Subject: FW: Notice of Exhibition - SSD 6917 - Oakdale South Industrial Estate, Erskine Park, Penrith LGA

Thank you for notifying WaterNSW of the exhibition of the EIS for Oakdale South Industrial Estate. WaterNSW has provided its advice/requirements previously to the Oakdale Central and more recently requested SEARS for Oakdale West. Thank you also for sending the hard copies of the reports and full size plans. Although WaterNSW appreciates the Department sending the hard copies, it is requested in future that only a CD and notification of the exhibited documents on the Department of Planning and Environment's website are sent for State Significant Development adjacent to the Upper Canal or Warragamba Pipelines, rather than the hard paper copies.

RE-ALIGNMENT
CREEK 2

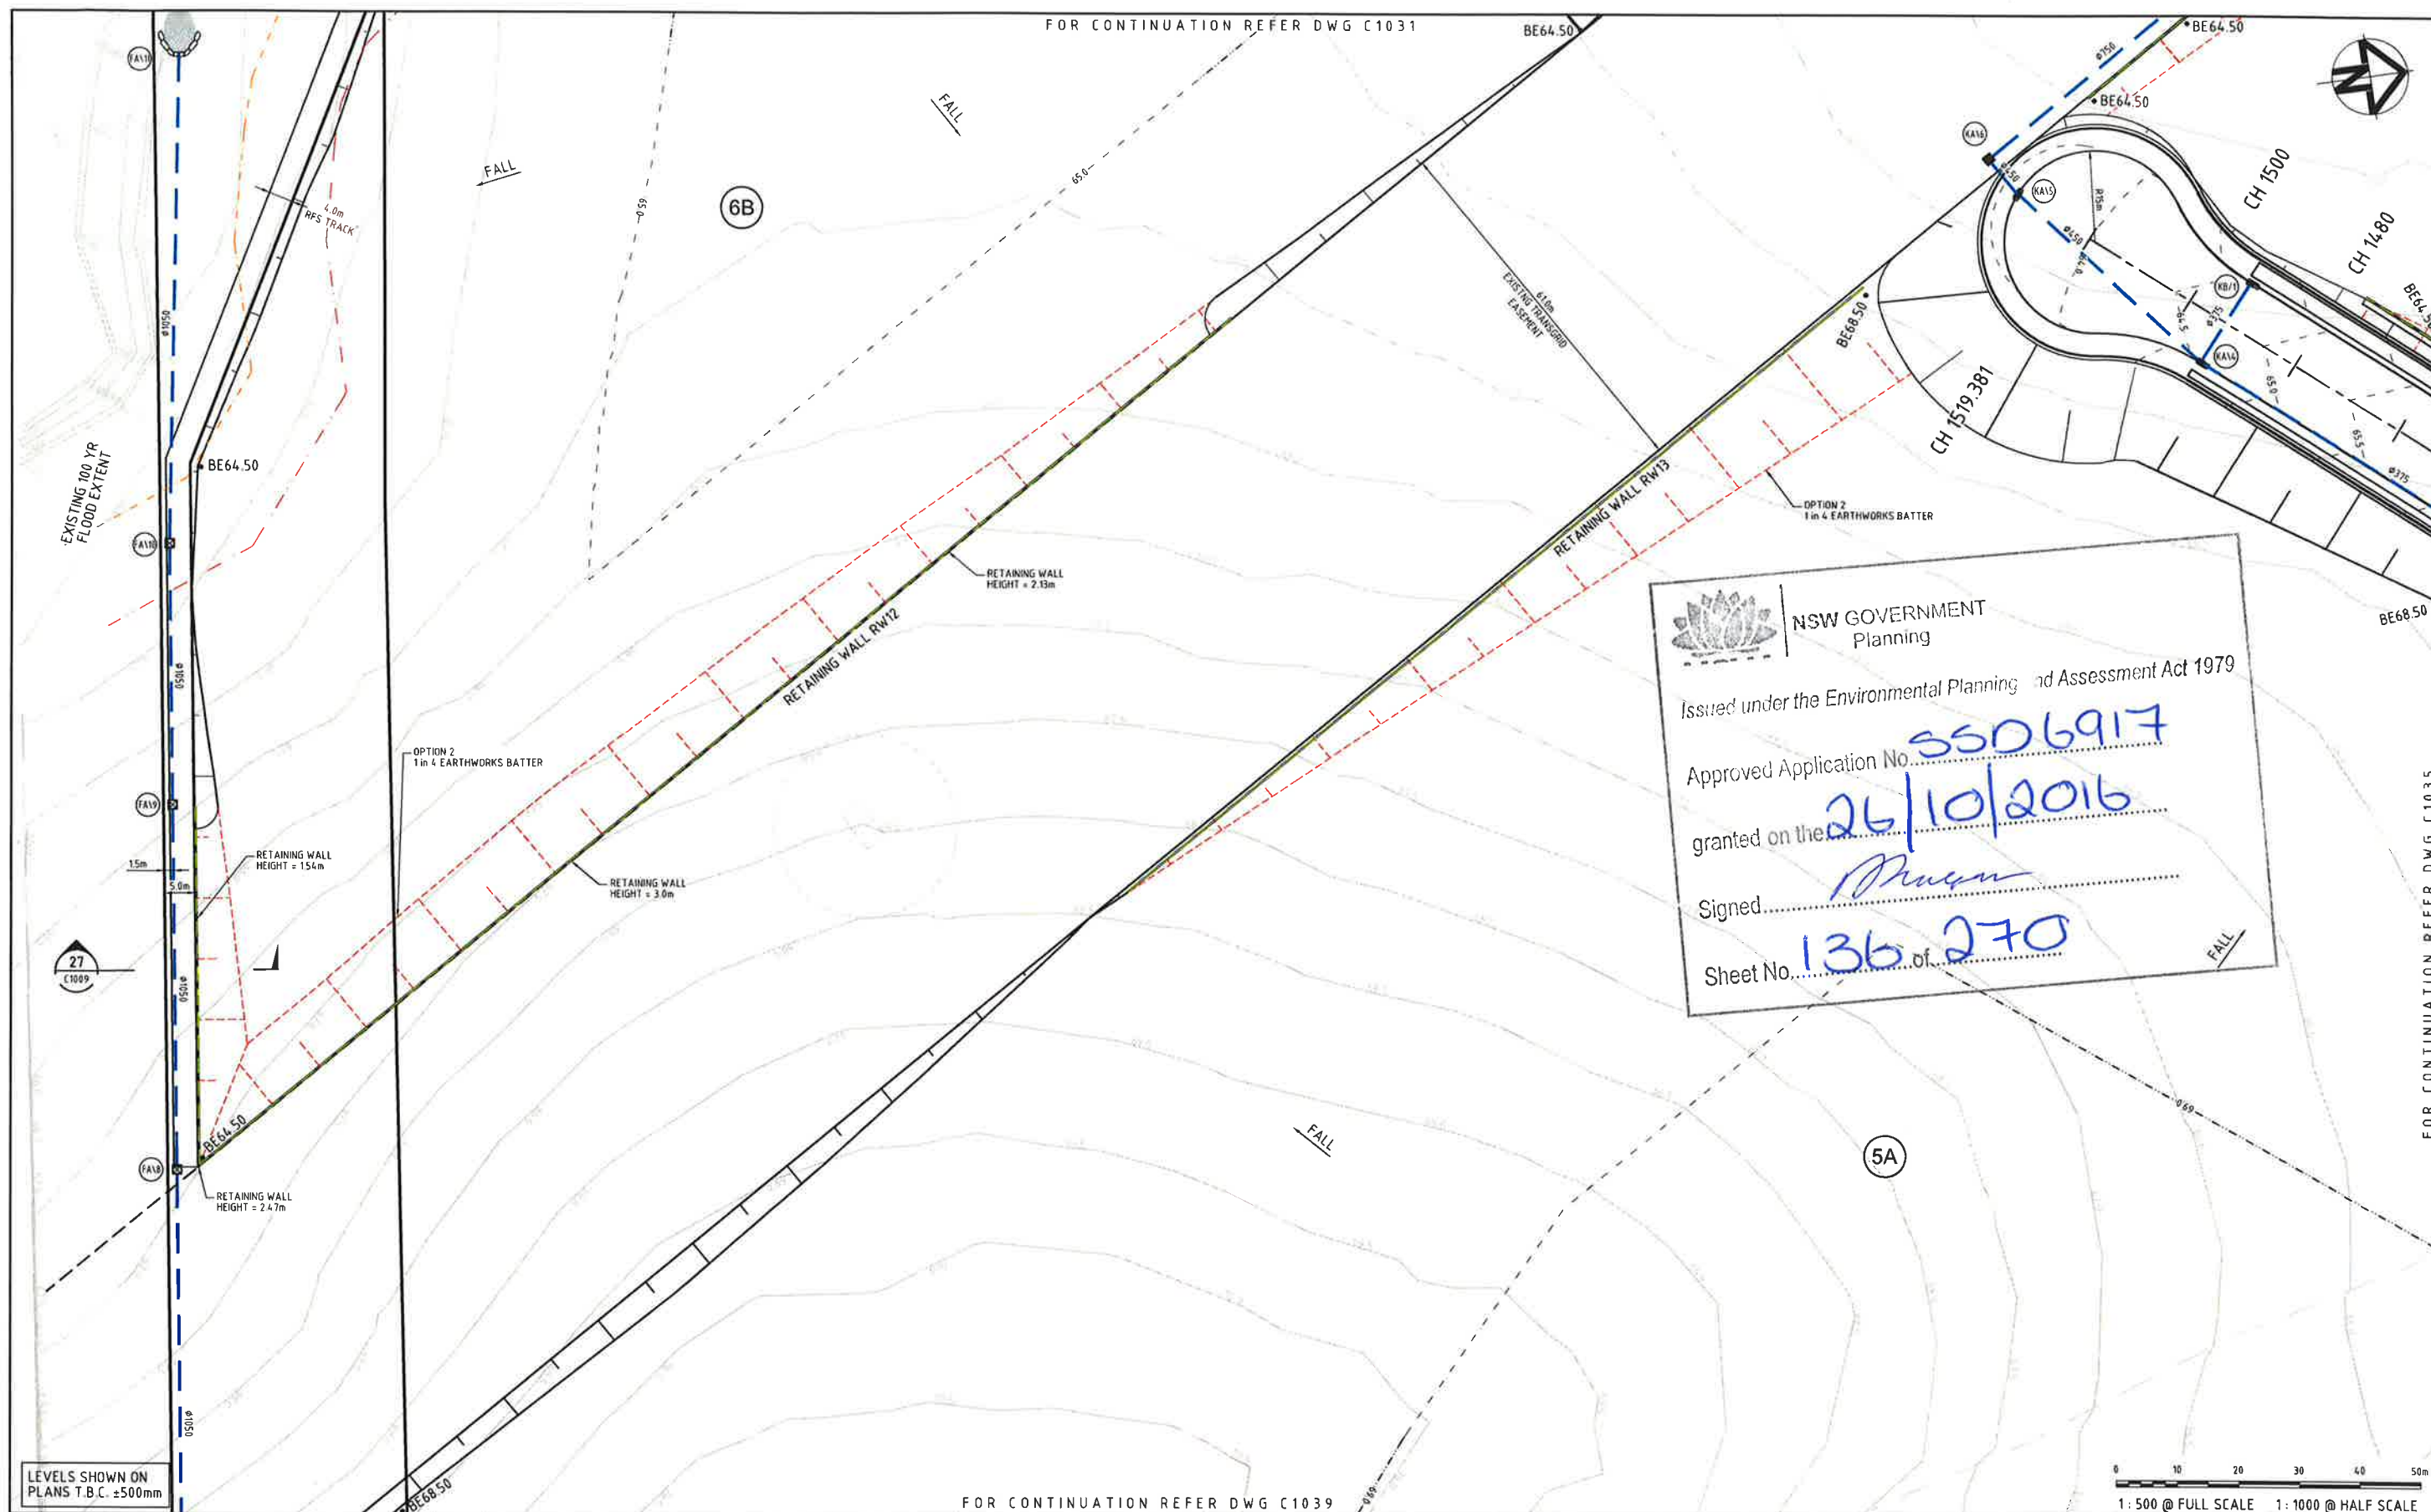
As Oakdale South is not directly adjacent to the Warragamba Pipelines corridor, the only issue that WaterNSW wishes to raise, is the need for any realignment or works carried out on Ropes Creek to be done in a manner that does not adversely impact downstream lands such as the Warragamba Pipelines corridor. Water NSW requires upstream and/or adjacent development to not result in an increase from current levels of stormwater entering the Warragamba Pipelines corridor.
